### **DEPARTMENT OF PUBLIC WORKS**

**RE:** Thayer SEPA, SV 19-00001

Public Works has reviewed the submitted materials for Thayer SEPA, SV 19-00001. Our comments appear below for your use.

THAYER PROPERTY DEVELOPMENT
 FOR SINGLE FAMILY RESIDENCE
 SECTION AT MIDDLE OF BRIDGE
 DRAWING 5

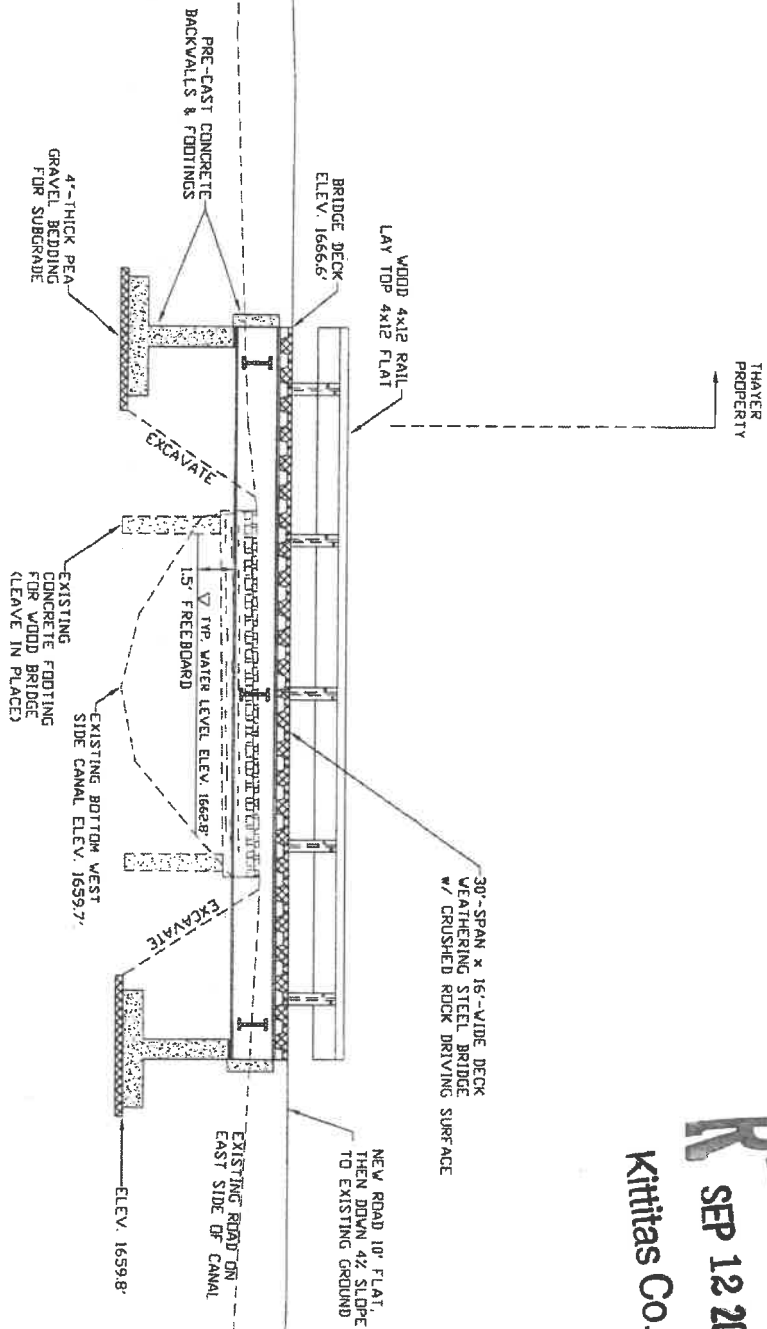
1. Applicant shall obtain a private bridge application from Public Works. Once received, Public Works will review engineering and provide final inspection of the proposed new private bridge.
2. A portion of the access driveway appears to be a candidate for widening within the delineated floodplain. Any fill in the floodplain will require a floodplain development permit. County code requires mitigation for floodplain fill.
3. The proposed parking area at the end of the driveway appears adequate meeting our required fire/life/safety turnaround.
